Description: Change of use from doctor's practice to 7no. apartment and 1no. studio flat including external extensions and alterations to building.

Site Address: Caxton House Surgery, 53 High Street, Grimethorpe, Barnsley, S72 7BB.

C: Existing Rear Elevation

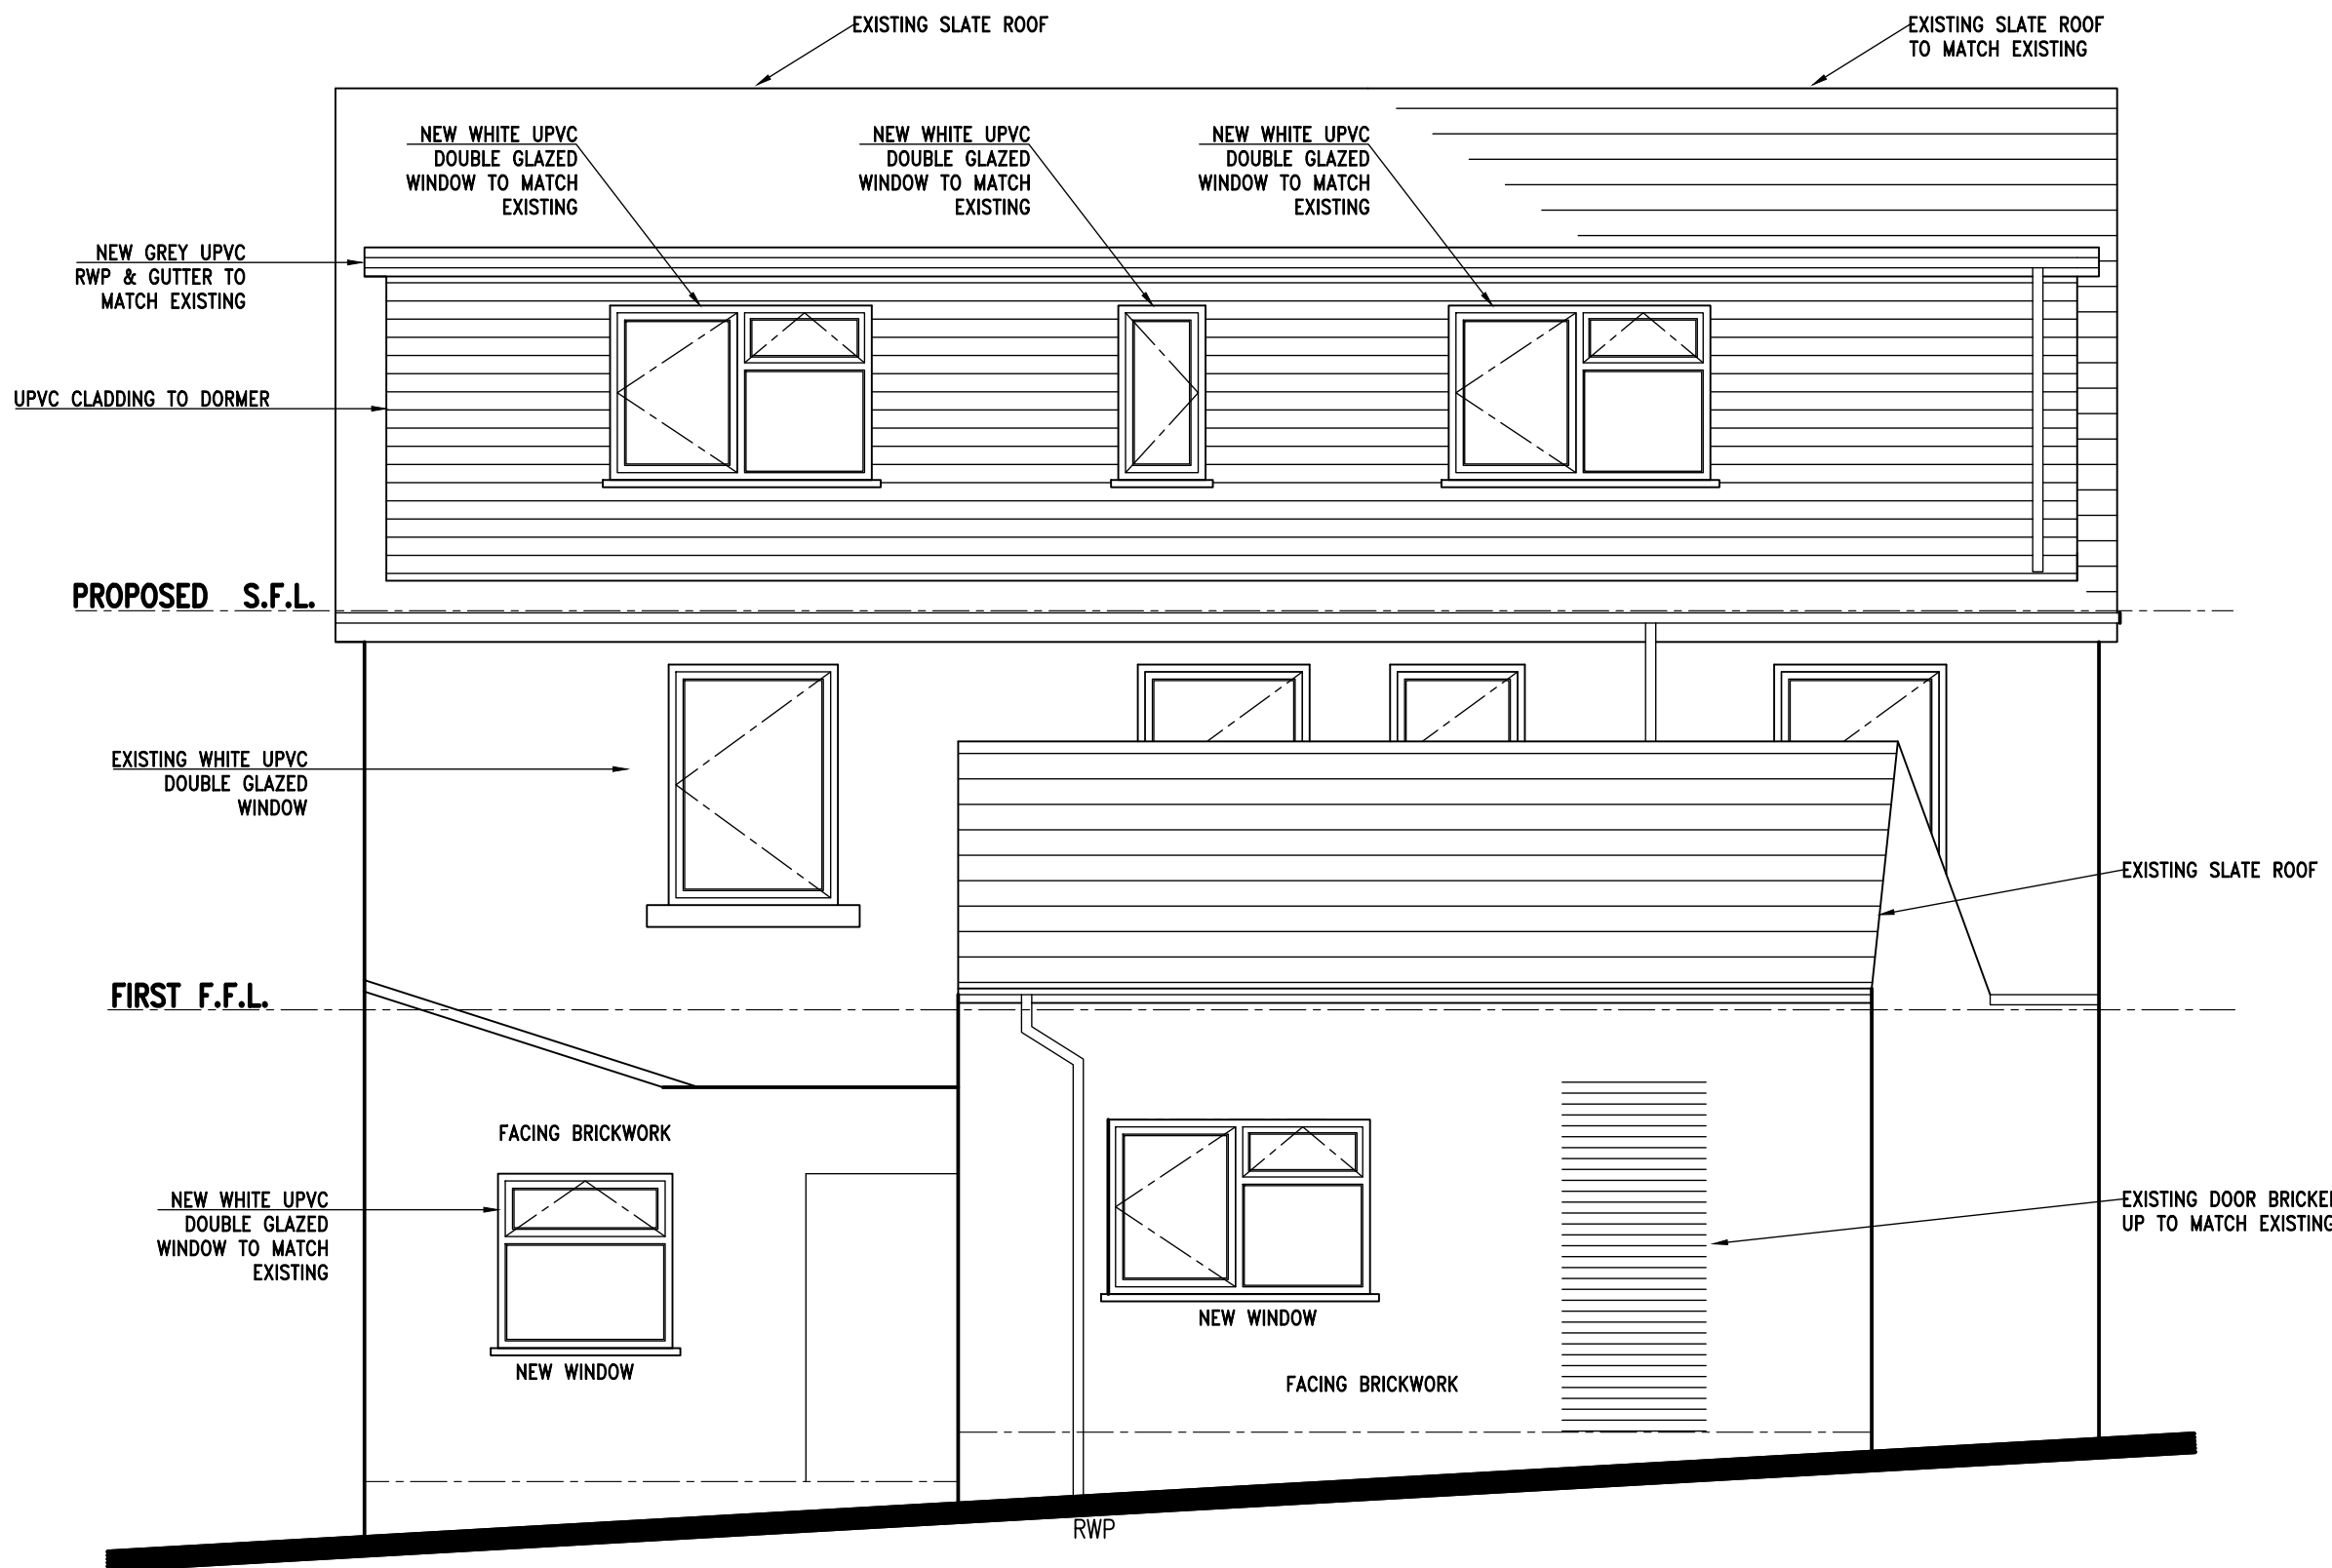
The conversion of the hipped roof to a gable would not increase the height of the roof and would be constructed from matching materials to the existing dwelling. There are existing properties within the immediate street scene with gable roof types and as such it is considered this alteration would be acceptable.

The SPD states that flat roof dormers are considered aesthetically inferior and are not normally acceptable and recommends guidelines which should be followed. The dormer is to the rear of the property and would not be highly visible from public vantage points. It is noted to the rear of the property there are existing garages and no residential properties. In terms of the guidelines the SPD specifies, the proposed dormer sits within the roof plane and the top of the dormer is below the ridge. The dormer is set back from the eaves by 0.46m which is a shortfall of 0.04m in what the guidance specifies and is set in from the adjacent property by 0.28m which is a shortfall of 0.22m. Although there is a small shortfall it is not considered detrimental considering the dormer has been set down and in, would not be highly visible and would again be constructed from matching materials to the existing dwelling.
